Rezoning Transportation Analysis

Petition Number: 2020-062

General Location Identifier: Tax ID 04545103

Date	Description
05-08-20	First Review (TVT)
08-25-20	Second Review (KP)

SHEET NUMBER
RZ-1

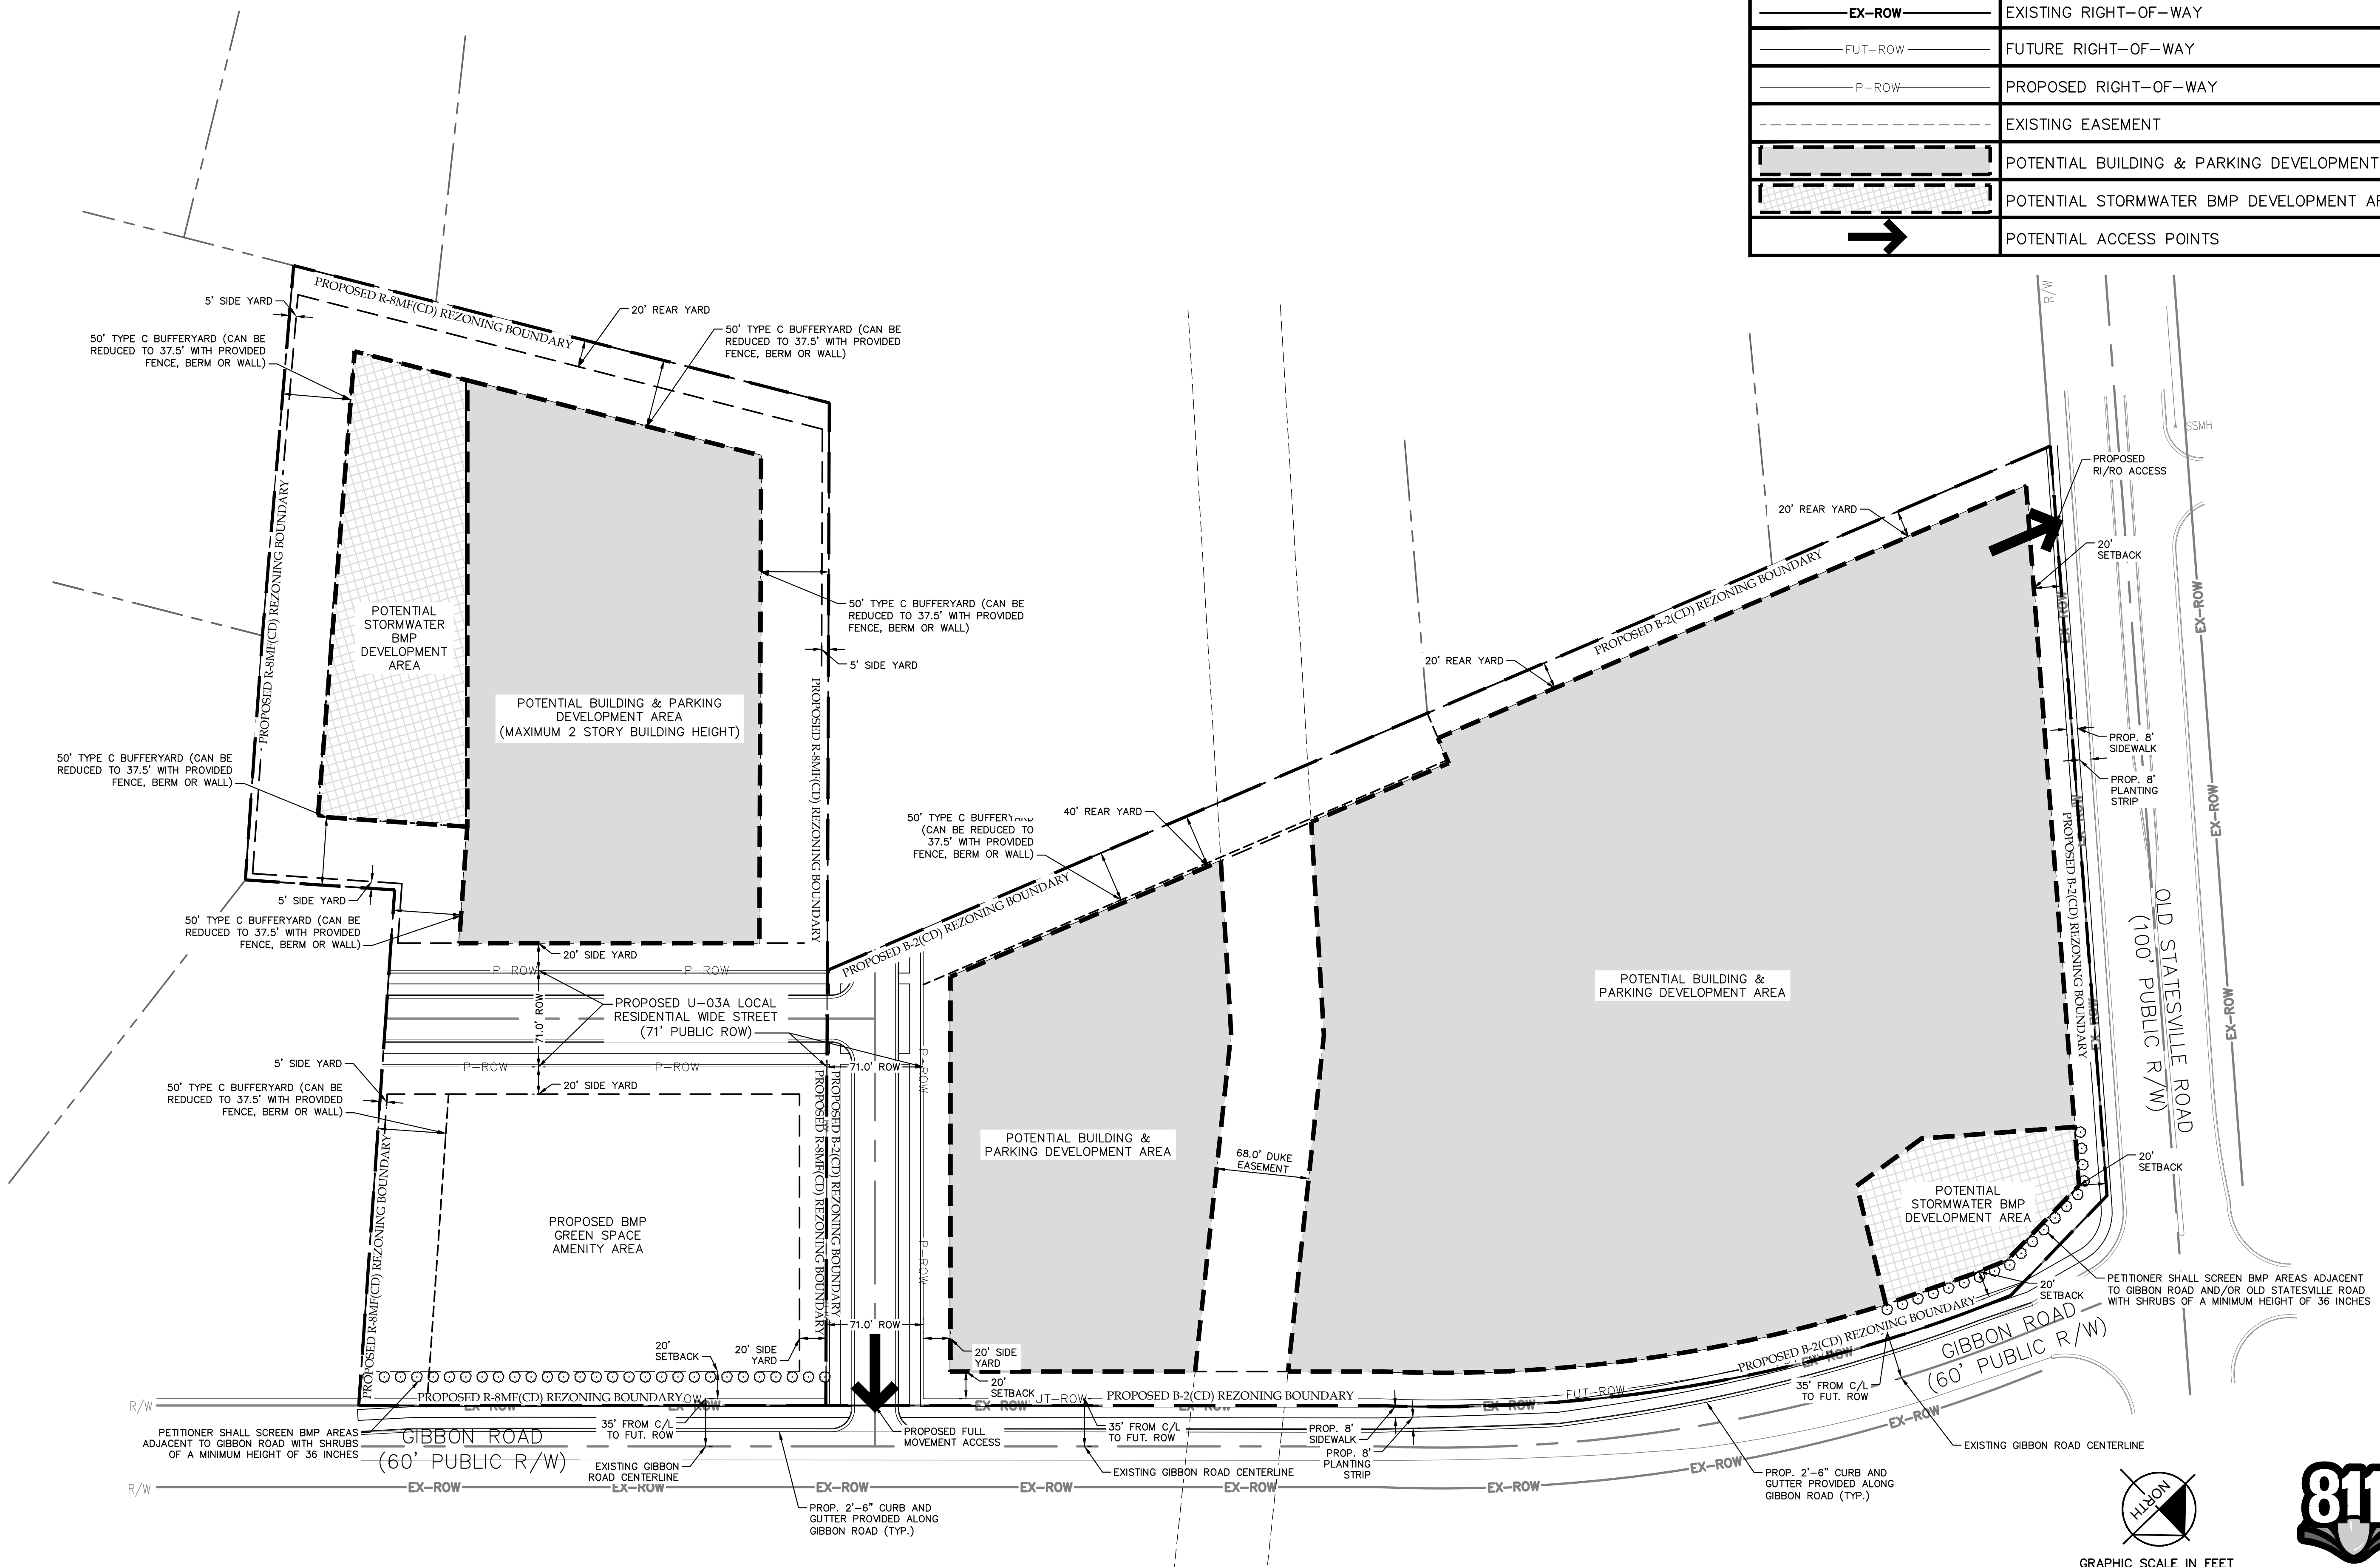
- New Comment (site plan dated 8-17-20)** The future back of curb and the 8-ft sidewalk, along Gibbon Road and Old Statesville Road, should be dimensioned from the center line of each road respectively.
- New Comment (site plan dated 8-17-20)** The petitioner should revise the site plan and conditional note(s) to provide the adequate bike facility along the petitioner's frontage of Gibbon Road, in accordance with Charlotte BIKES.
